Engineers Comments Regarding Condition 3

APPLICATION P/107/18/DOC

Site Address: 7 Webb Close, Bognor Regis, PO21 4YB

Application for approval of details reserved by conditions imposed on planning reference P/107/16/PL relating to condition 3 (Surface Water Drainage), 5 (Landscaping) & 14 (External Lighting)

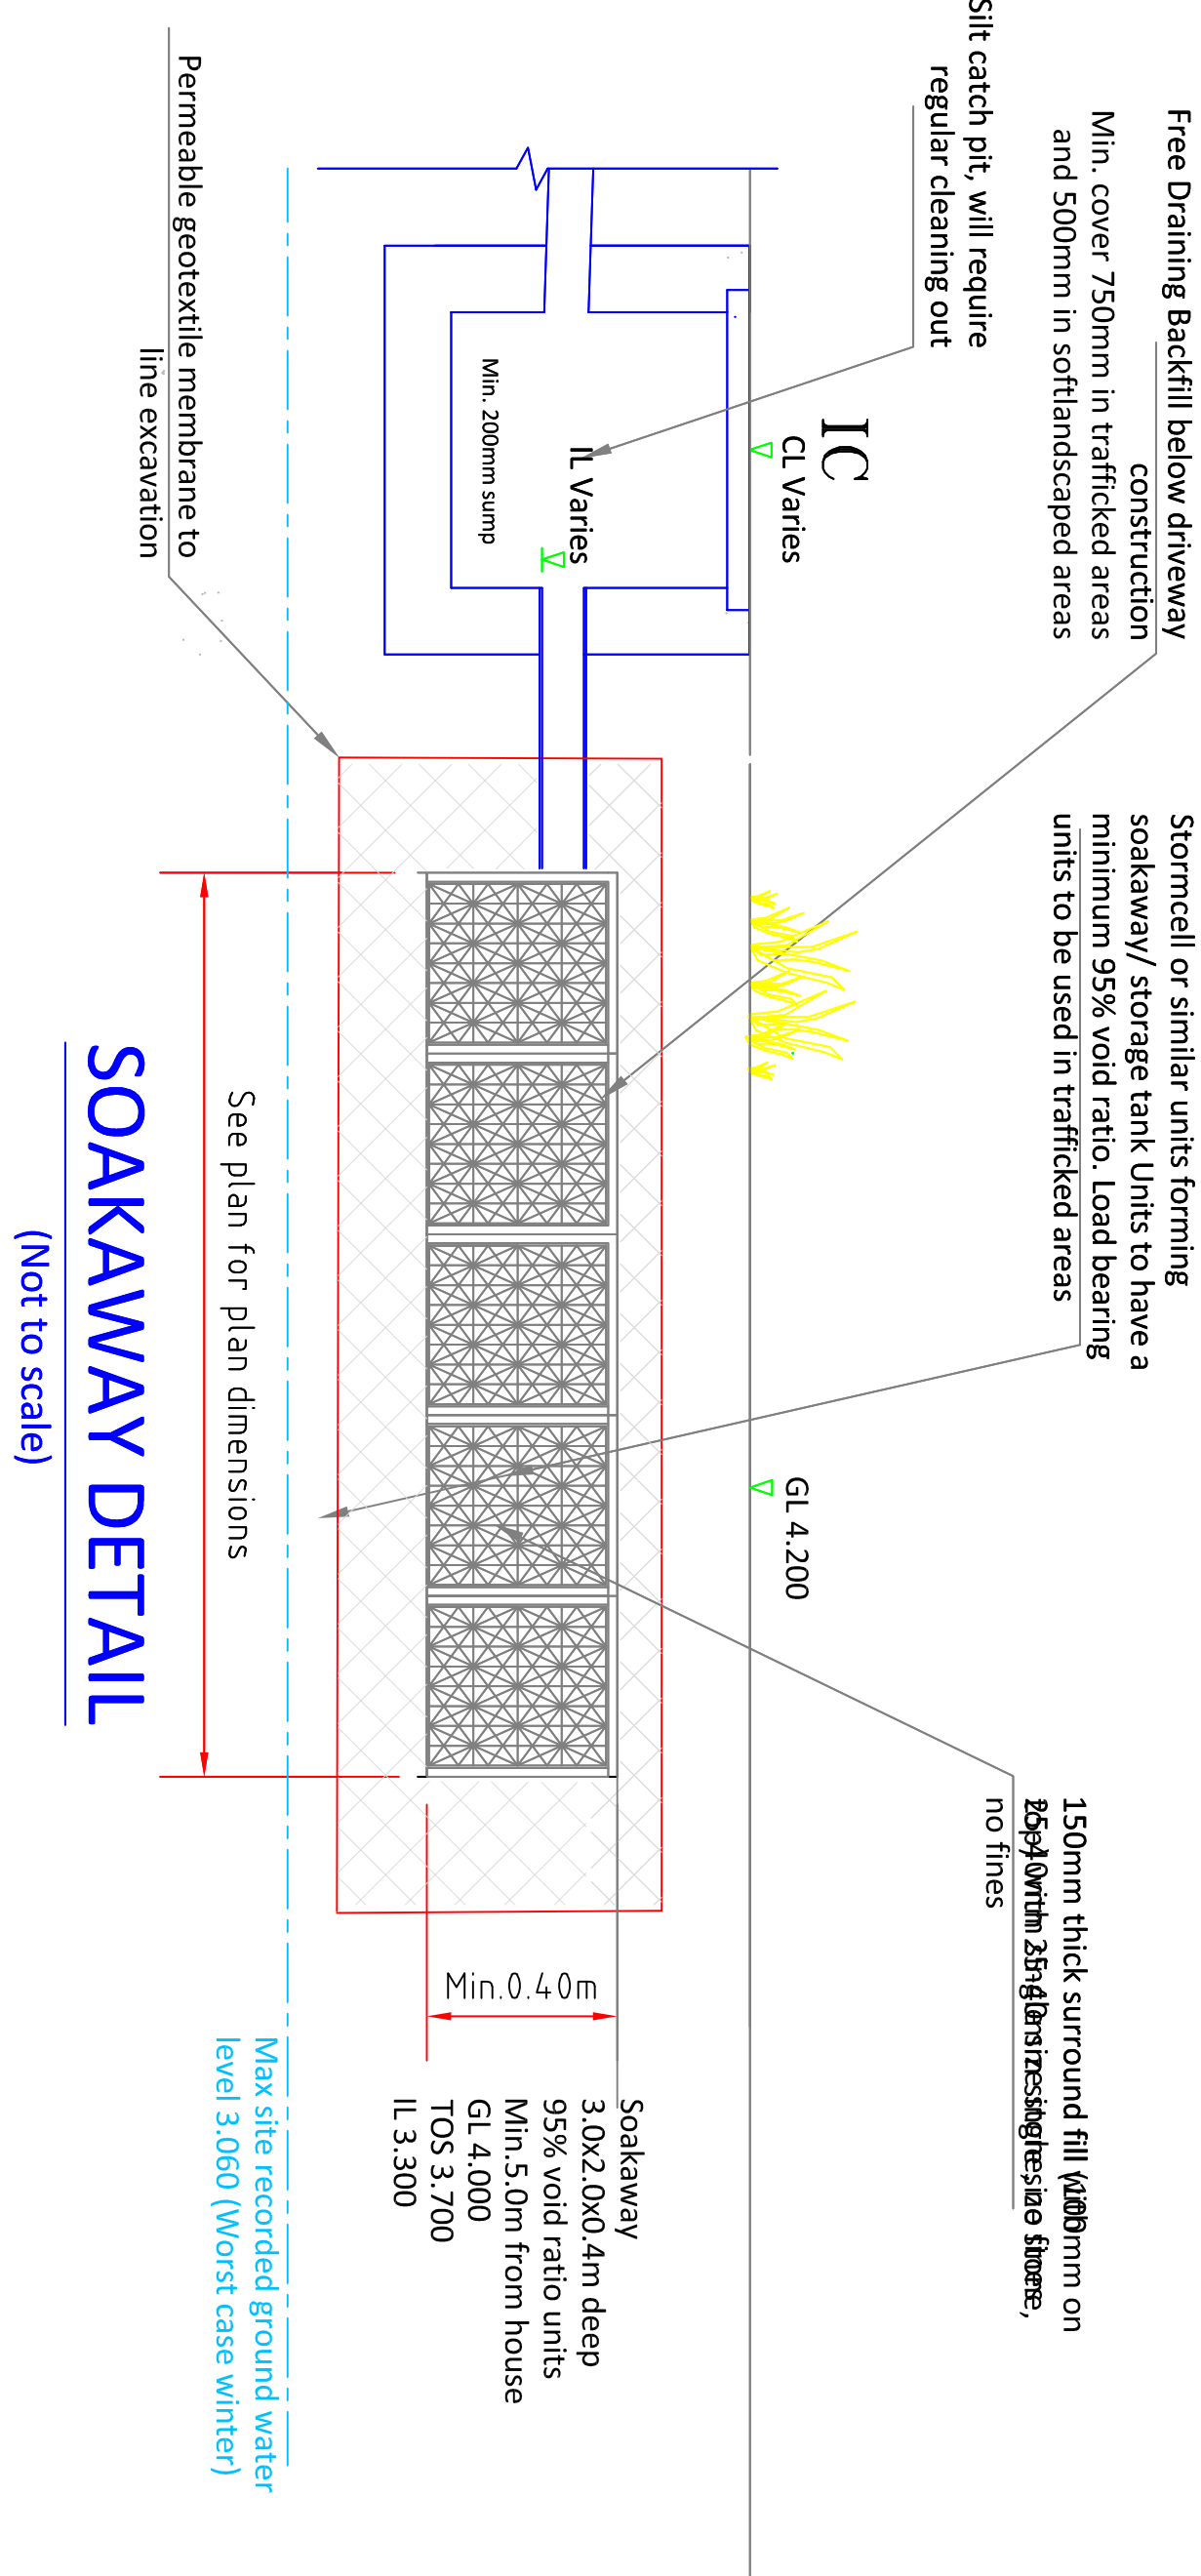
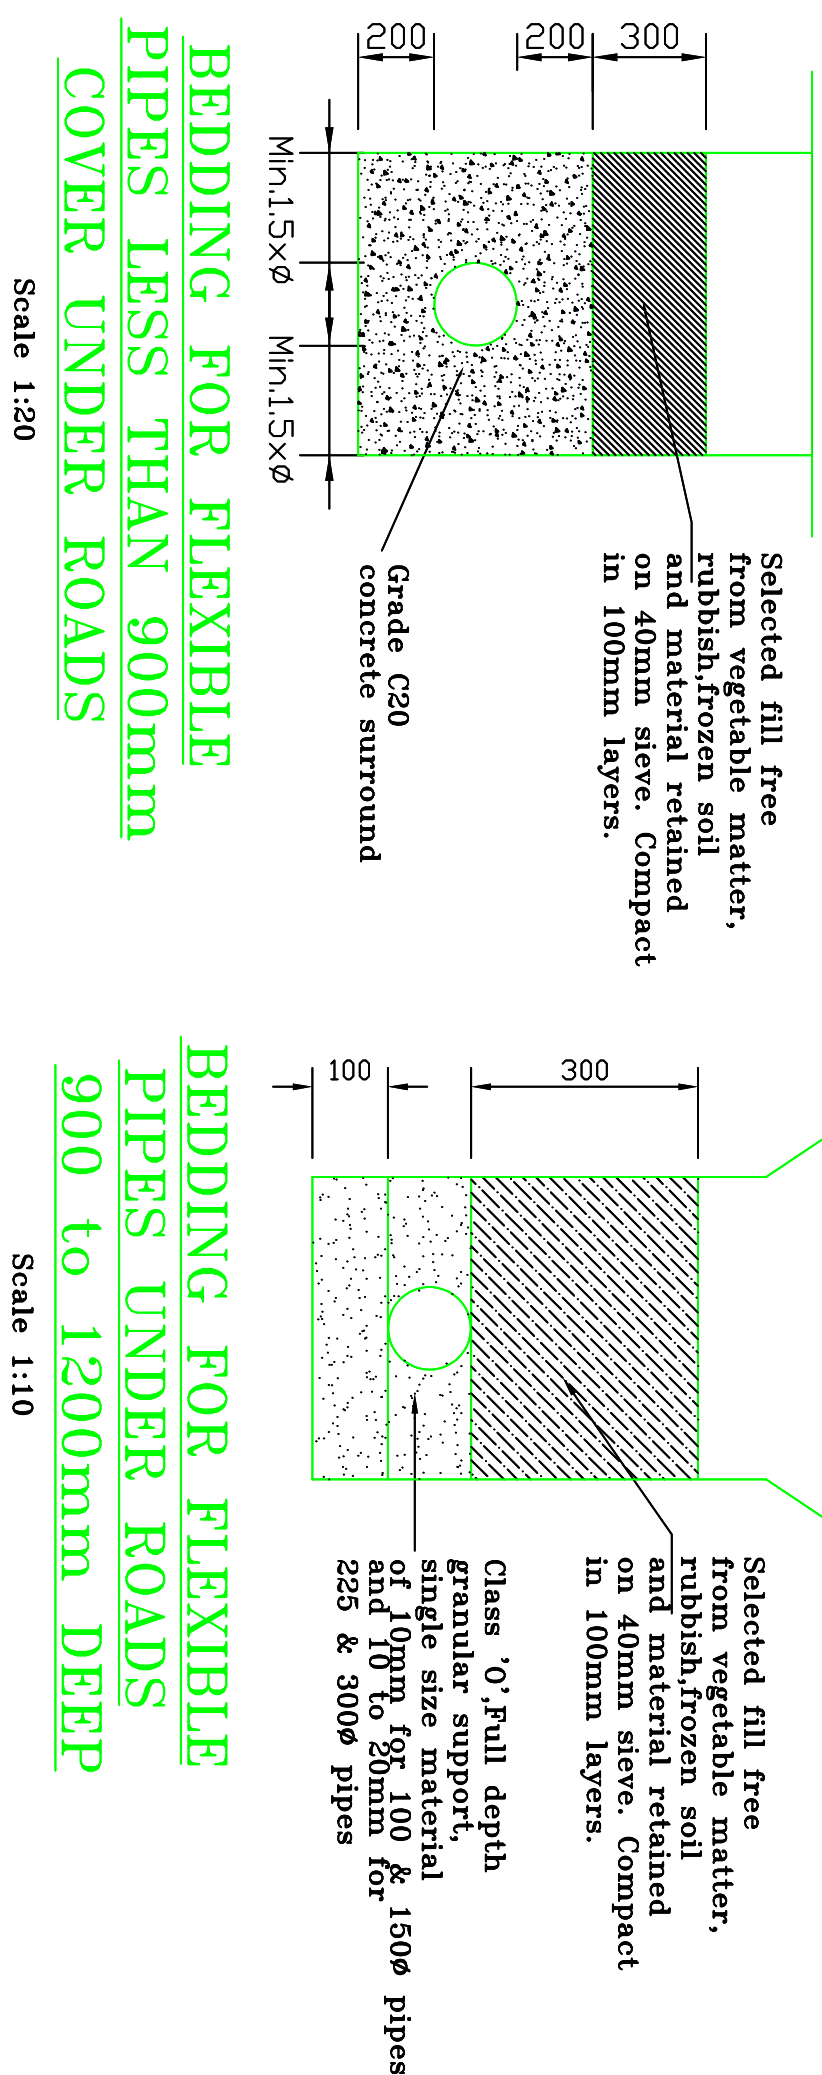
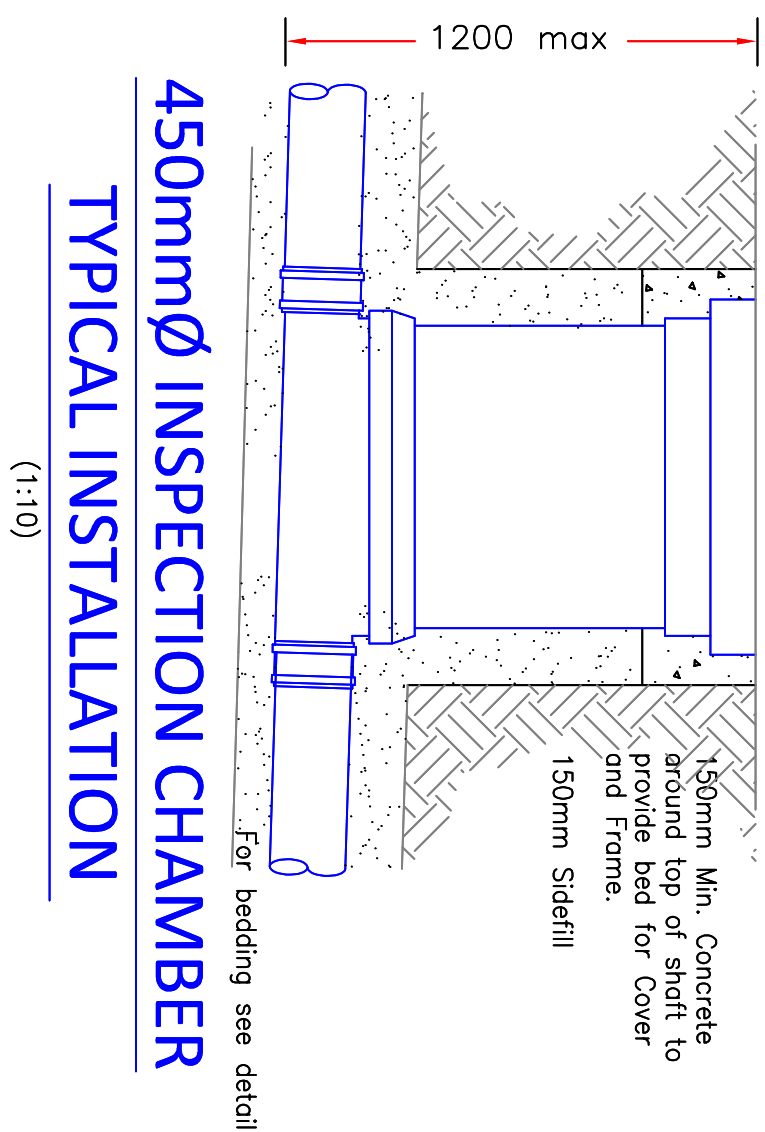
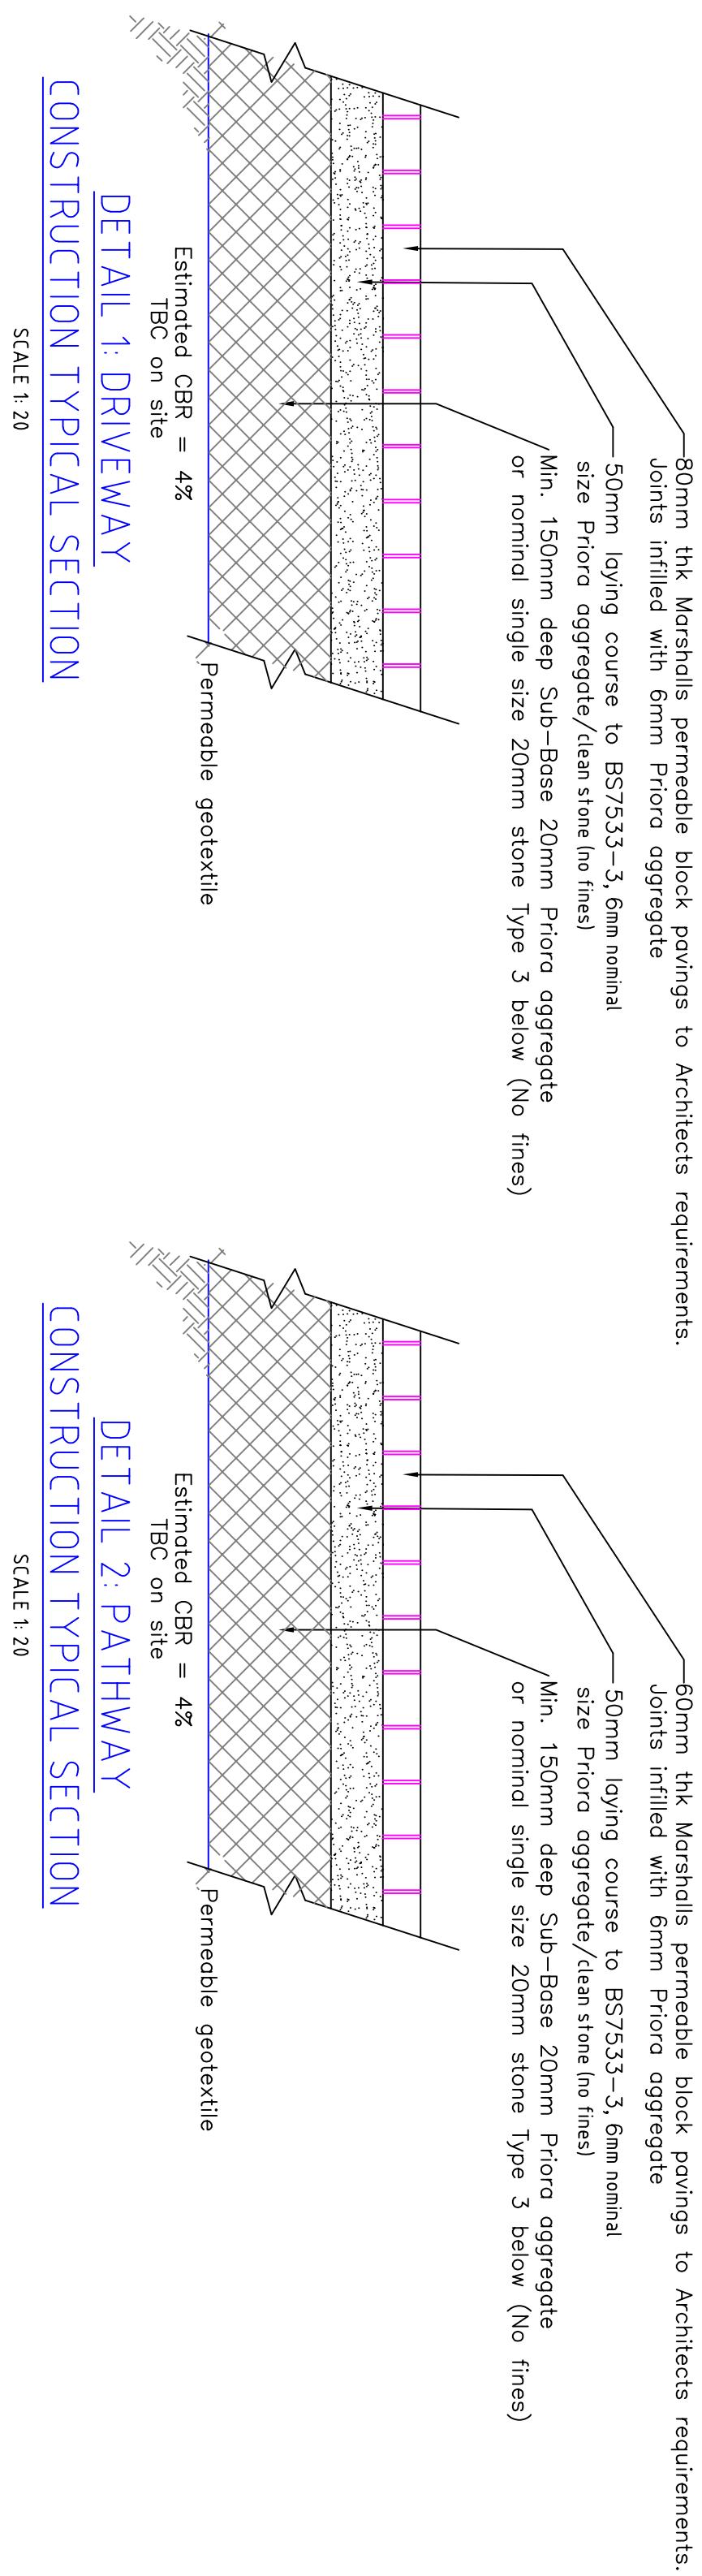
The construction detail drawings provided demonstrate that there is an issue with the surface water drainage design. The soakaway crates proposed require a cover depth of 500mm in soft landscaped areas and 750mm in trafficked areas. Yet only 0.3m cover depth is proposed. Please specify stronger crates or alternative cover arrangements.
